From: Nicola Oktay on behalf of Planning.Responses
Sent: 17 September 2024 09:38
To: Planning Scanning
Subject: FW: Land at Woodgate Nurseries, Lidsey Road, Woodgate AL/89/24/OUT
Attachments: Response table to AL-89-24-OUT LLFA comments FINAL.pdf

We refer to your planning consultation response for Land at Woodgate Nurseries, Lidsey Road, Woodgate AL/89/24/OUT.

Response table to WSCC (LLFA) issues raised (extract) to planning application AL/89/24/OUT

SURFACE WATER DRAINAGE STRATEGY AREA 1

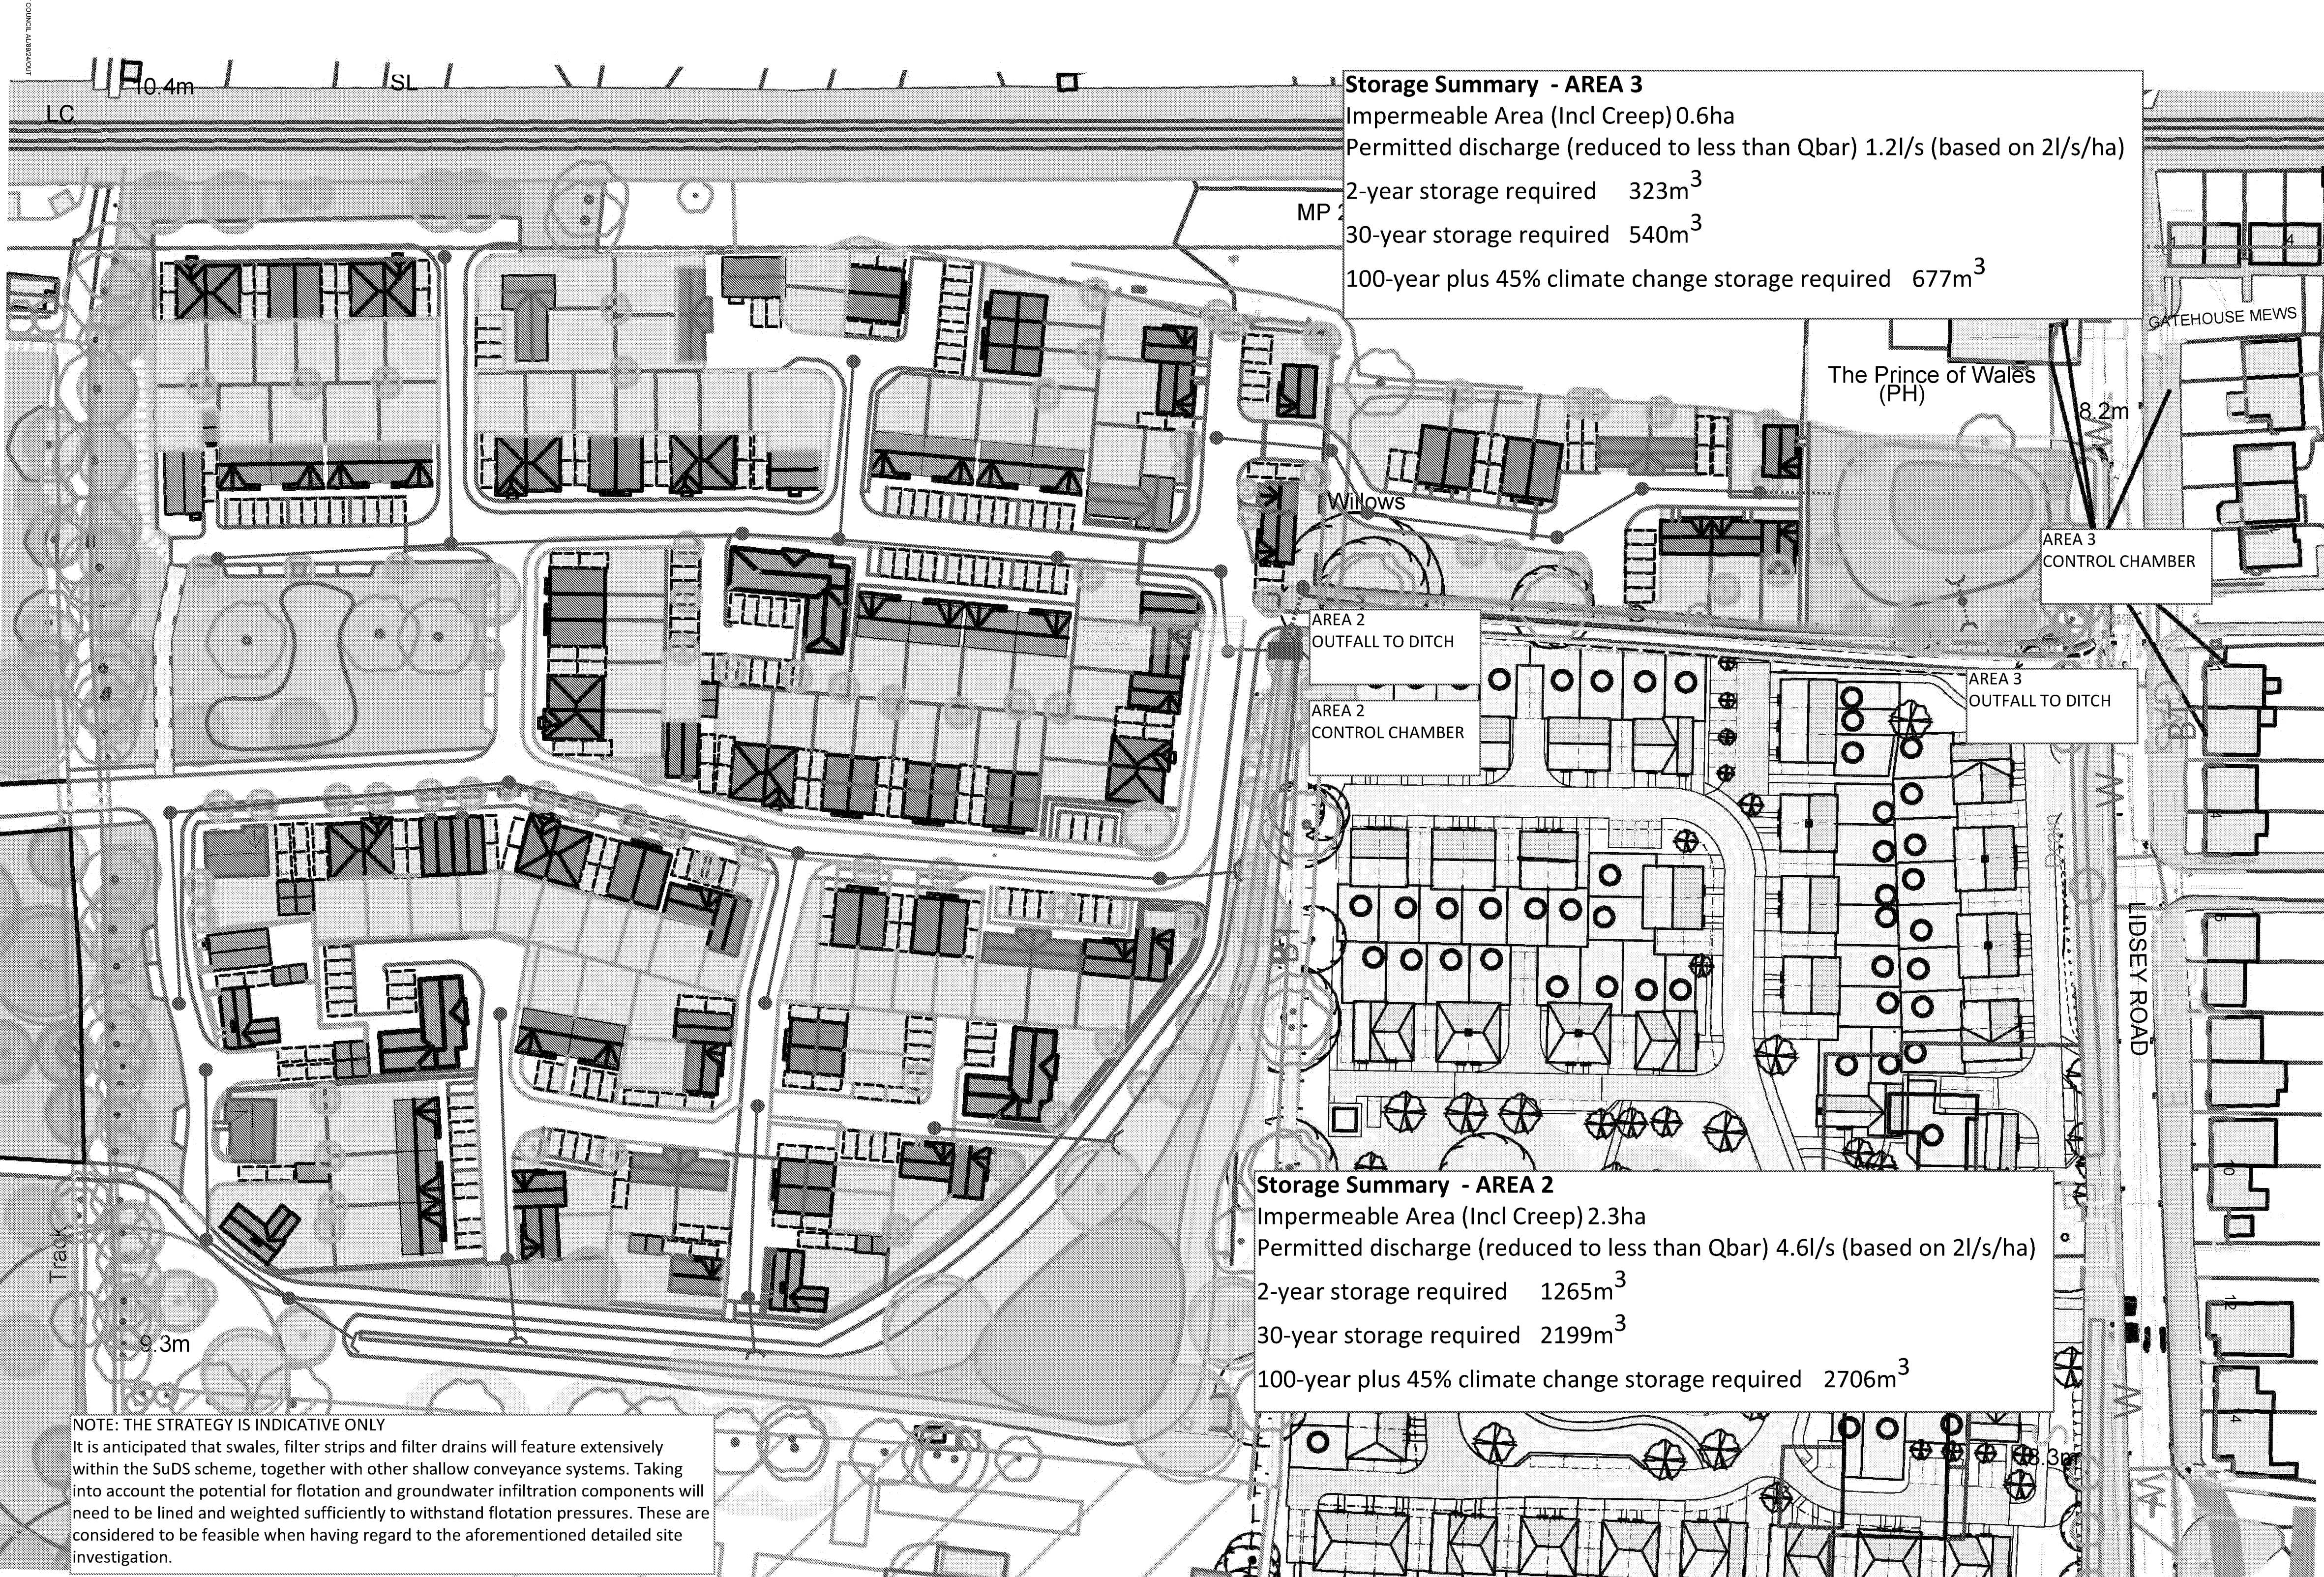
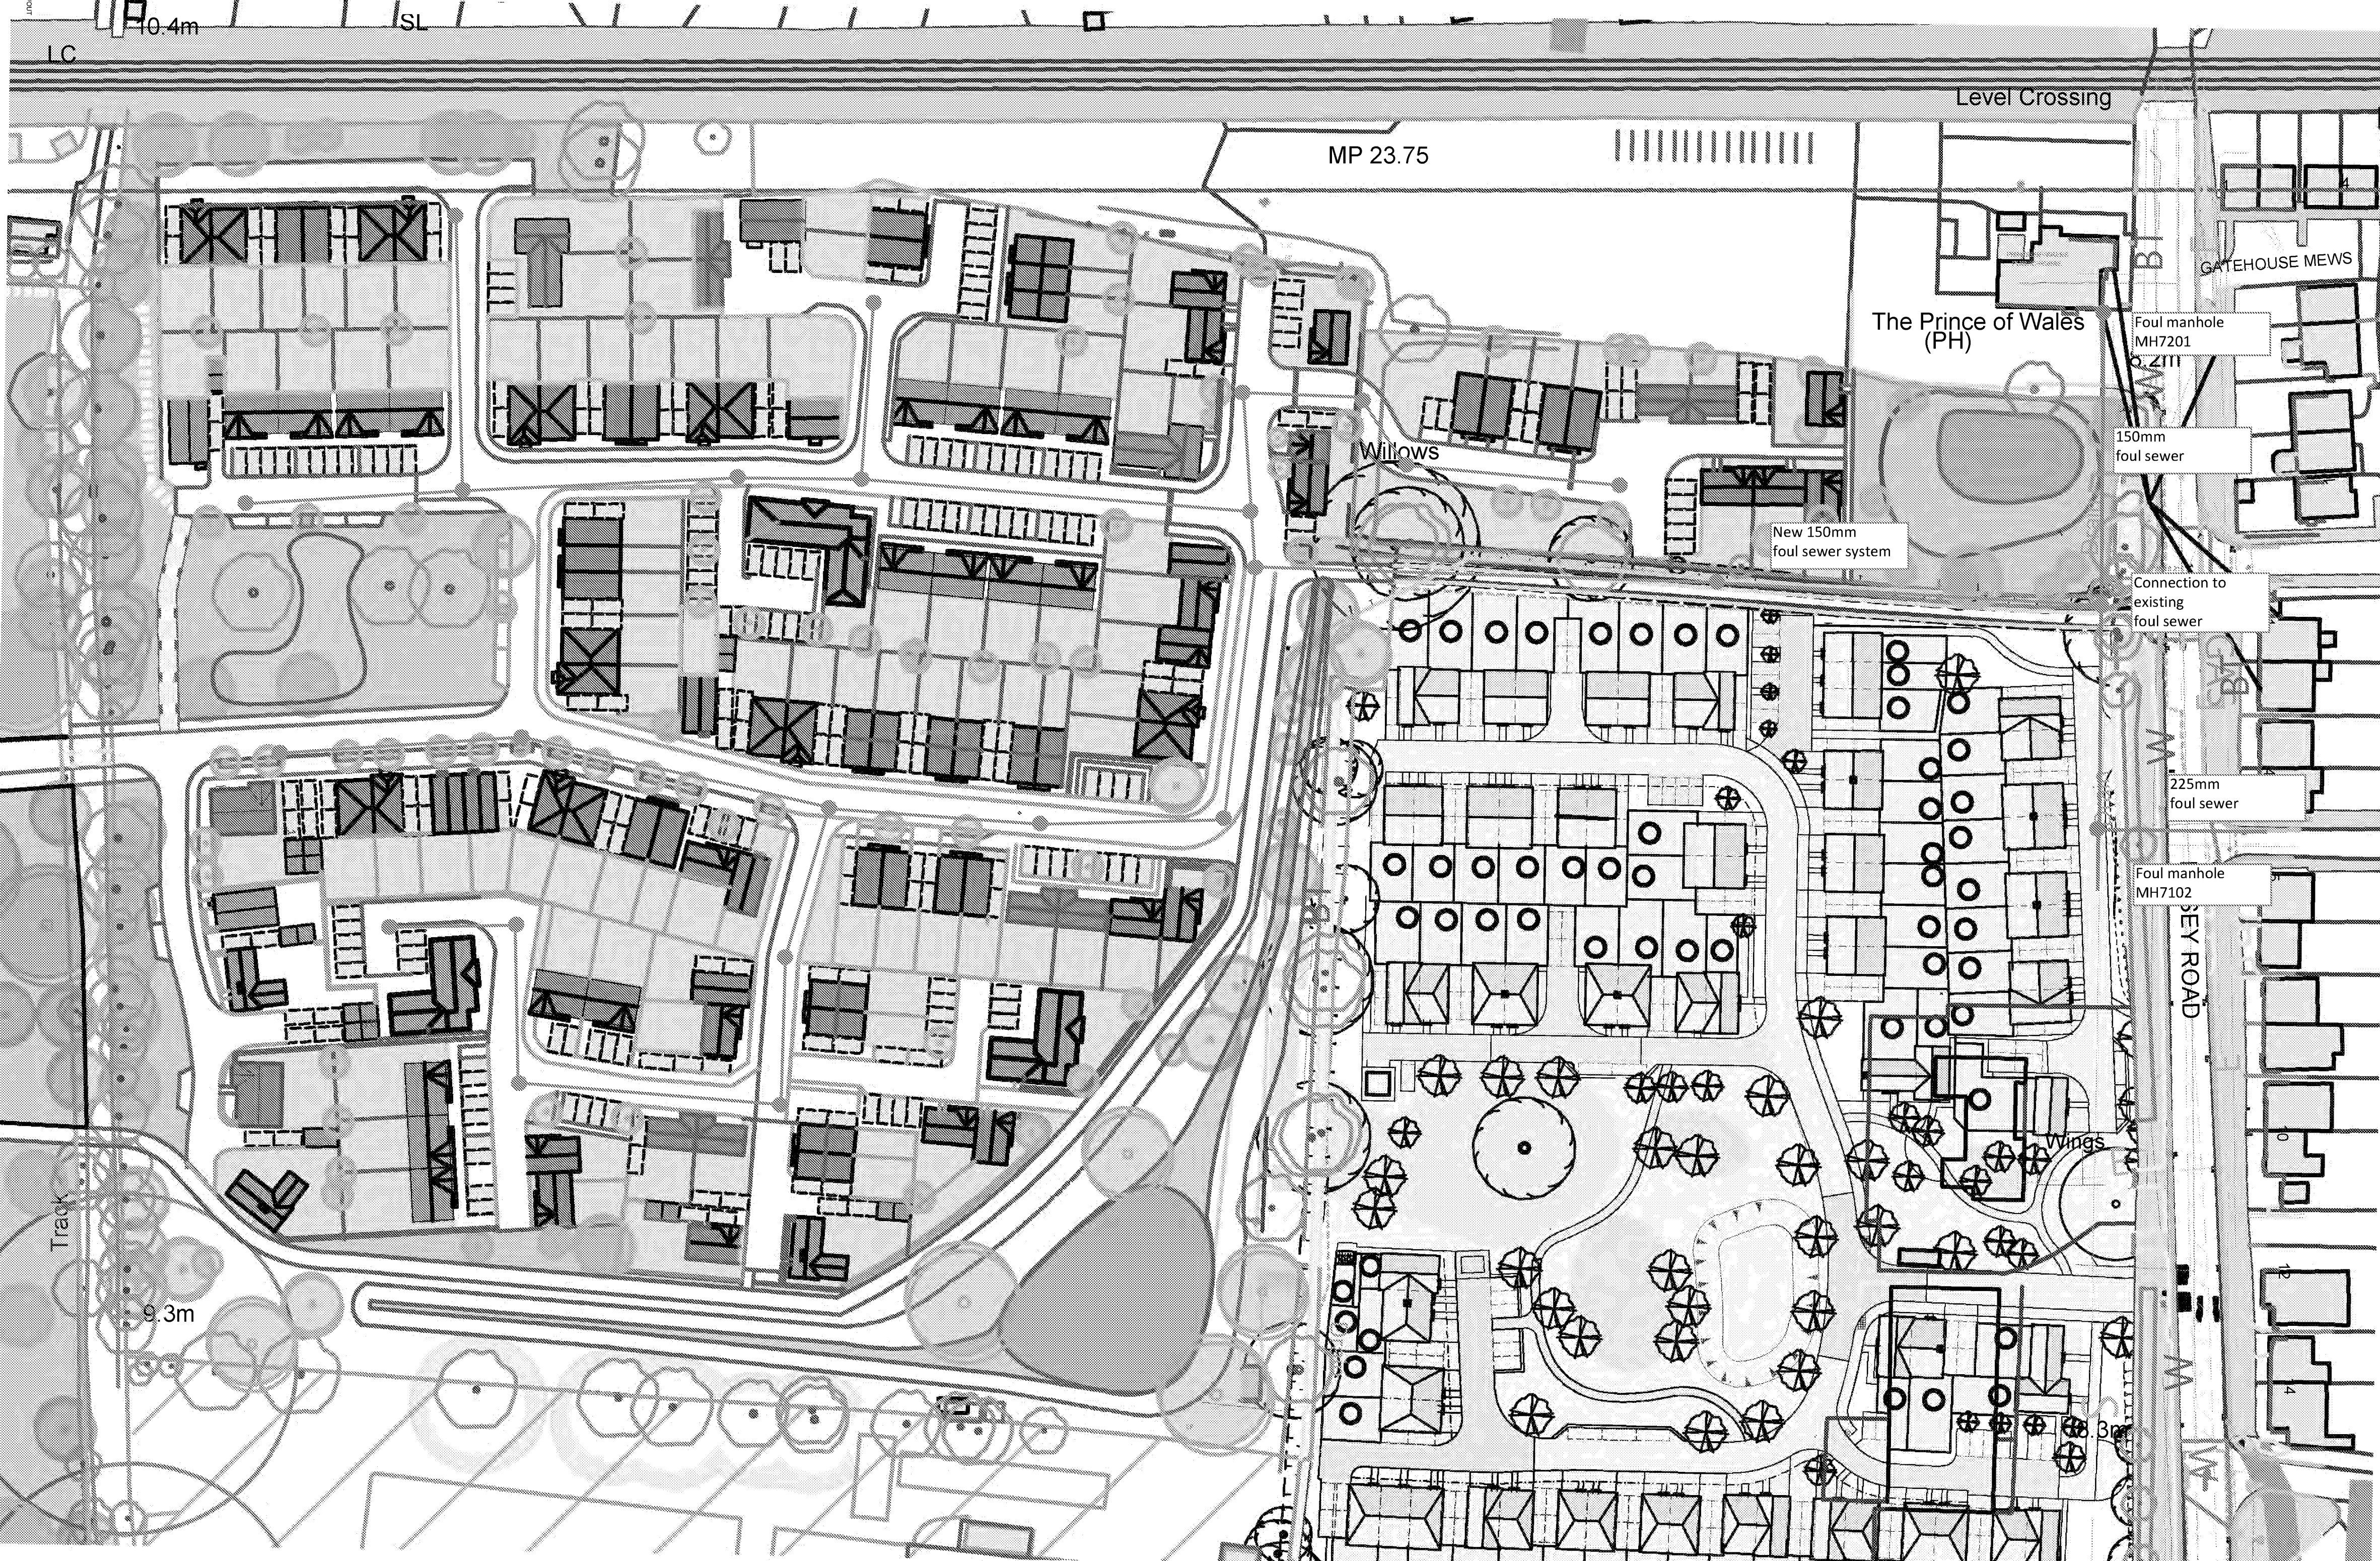
When checking the impermeable areas I did come across an error on my part. The measured impermeable area for AREA3 is actually 0.22Ha (NOT 0.6Ha). I had carried out an earlier iteration during design with a bigger AREA3 and inadvertently put those figures into the document.

Outline drainage modelling calculations should be resubmitted and demonstrate how 10% urban creep has been included in the volume of SuDS storage required.	Objection: Please provide further details.	For each of the subcatchments the roof and paved areas have been measured. 10% addition for creep was then added. AREA 1 (Road only) Roof area = 0 Paved area= 0.3Ha Combined=0.3Ha No allowance for creep as access road only

AREA 1 (Road only)
Roof area = 0
Paved area= 0.3Ha
Combined=0.3Ha
No allowance for creep as access road only

AREA 2
Roof area = 0.7387Ha
Paved area= 1.3472Ha
Combined=2.0859Ha
Creep allowance=0.215Ha
Total = 2.3009Ha (2.3Ha)

AREA 3
Roof area = 0.0736Ha
Paved area= 0.122Ha
Combined=0.1956Ha
Creep allowance=0.02Ha
Total = 0.2156Ha (0.22Ha)

NOTE
The modelled impermeable area for AREA 3 in the FRA of 0.6Ha is in error. The measured area is 0.22 Ha.

AREA 2 Roof area = 0.7387Ha Paved area= 1.3472Ha Combined=2.0859Ha Creep allowance=0.215Ha Total = 2.3009Ha (2.3Ha) AREA 3 Roof area = 0.0736Ha Paved area= 0.122Ha Combined=0.1956Ha Creep allowance=0.02Ha Total = 0.2156Ha (0.22Ha) NOTE The modelled impermeable area for AREA 3 in the FRA of 0.6Ha is in error. The measured area is 0.22 Ha. This is now corrected and the FRA updated accordingly.
How will the drainage and watercourse features be managed and maintained?	NPPF Paragraph 175 PPG Paragraph 055, 057 and 058 SDNSTS S10, S11, S12, S13 and S14	Provide an easement of a minimum of 3m from the top bank of any watercourse. This should be on both banks, but justification should be provided if access is proposed from only one side of the bank or less than 3m (e.g. 2.5 times the width of any plant likely to be used (from the top of bank with maintenance plant parallel to the watercourse)).	Objection: please show on drawings.	Please note; a) This application is submitted in outline for up to 130 dwellings – layout and landscaping are reserved matters at this stage and are not being considered in detail – therefore showing ‘on drawing’ is not suitable as those are likely to change.
